DRB Application No.: 05DRB-01712 (P&F)	Project # 1004322
Project Name: LOS HERMANOS ADDITION	
Agent: Surveys Southwest	Phone No.: 998-0303

CITY OF ALBUQUERQUE
Planning Department
November 16, 2005
DRB Comments

RE: Los Hermanos Addition/p&f plat

DEVELOPMENT REVIEW BOARD--SPEED MEMO

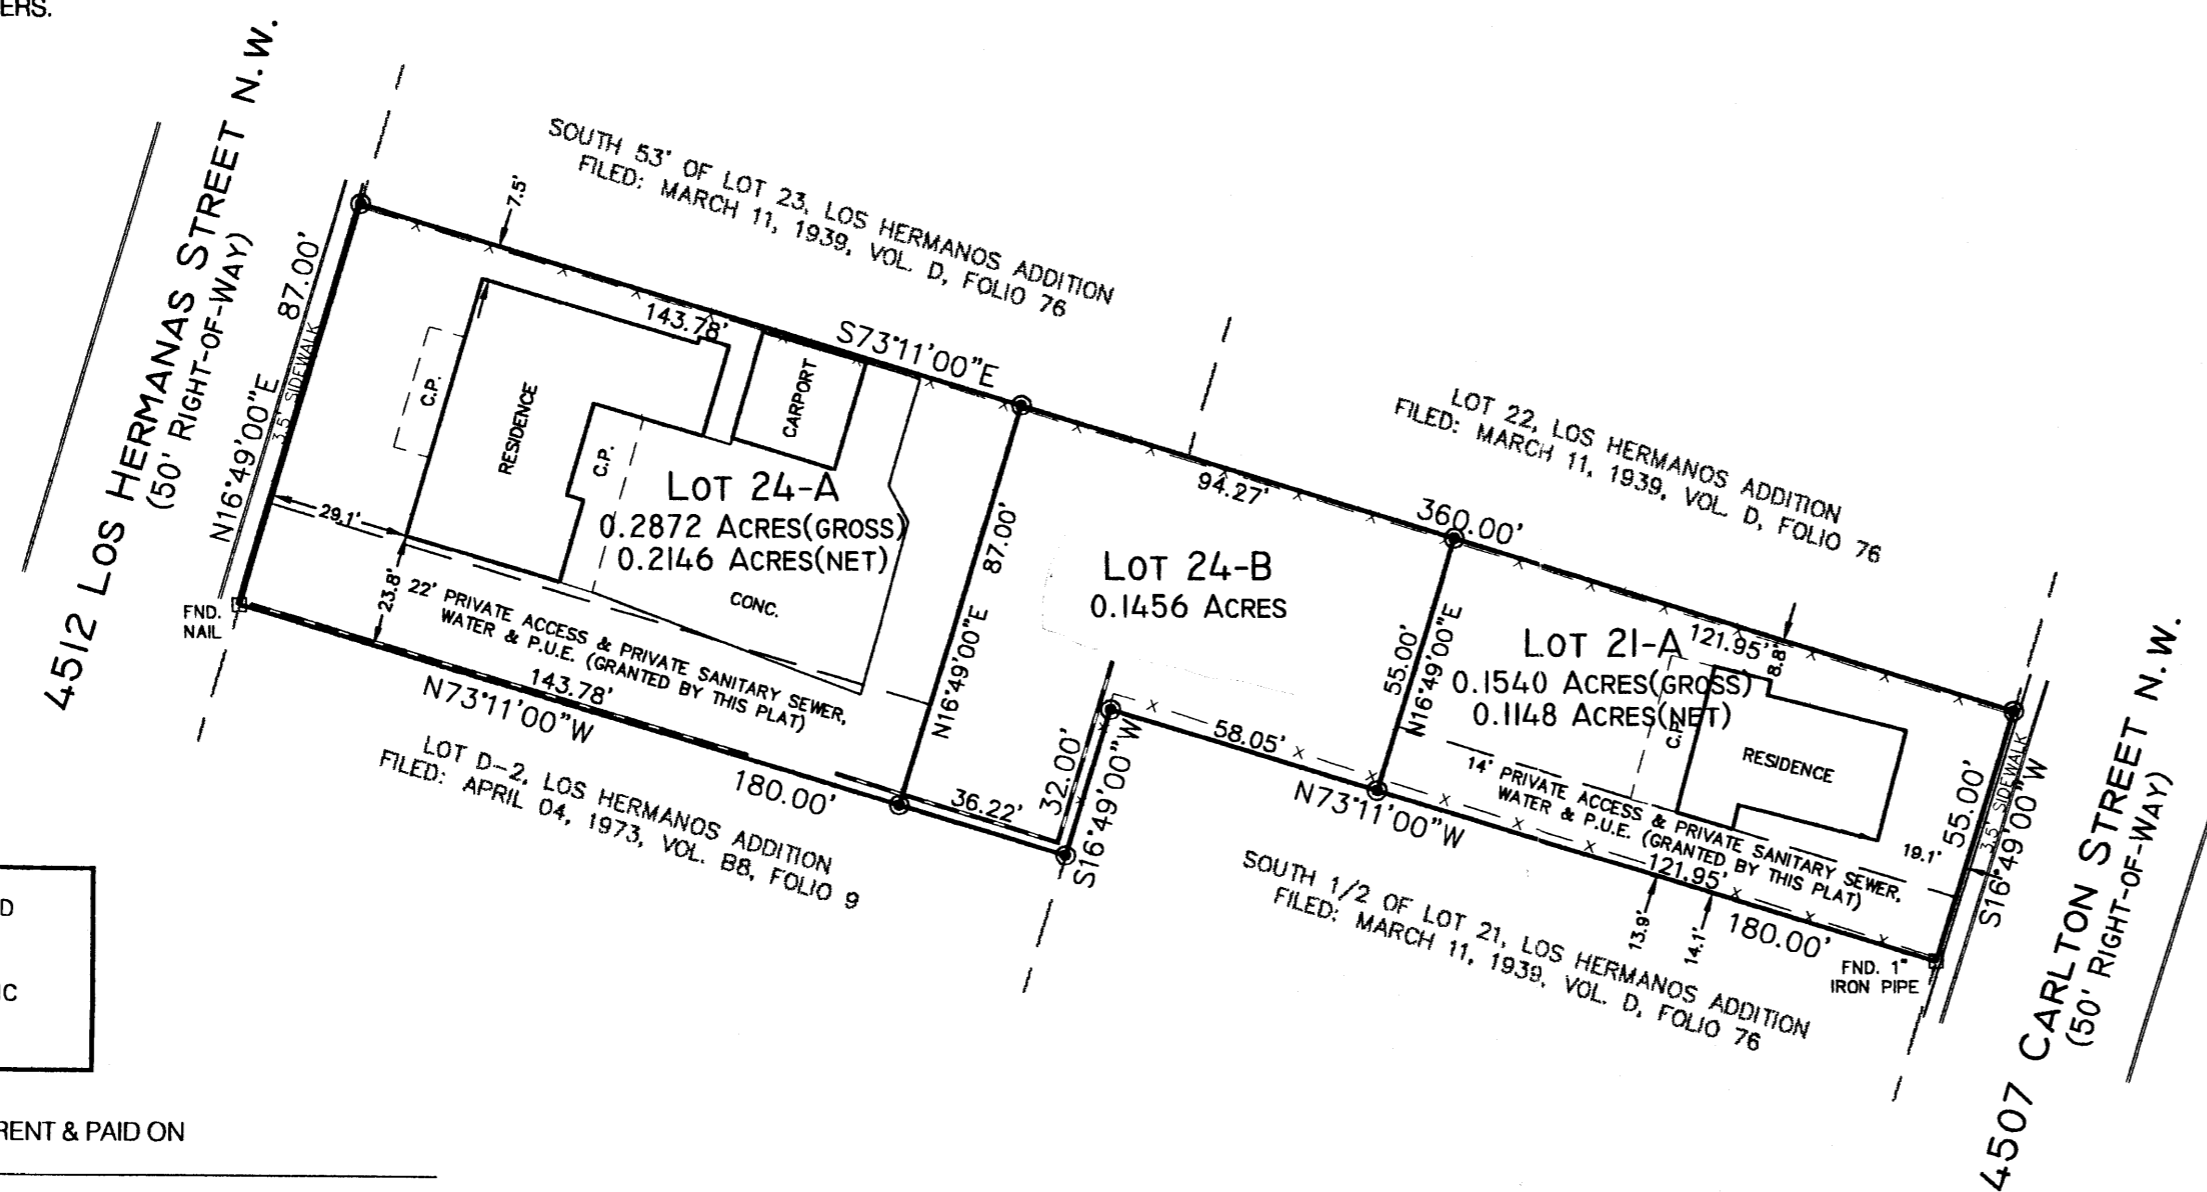
Need private drainage easement.

A Drainage Easement must be included in the Private Access, Sanitary Sewer, Water, and PUE easement.

The 14 foot access easement does not benefit Lot 24A, only 24-B as shown on the sketch plat.
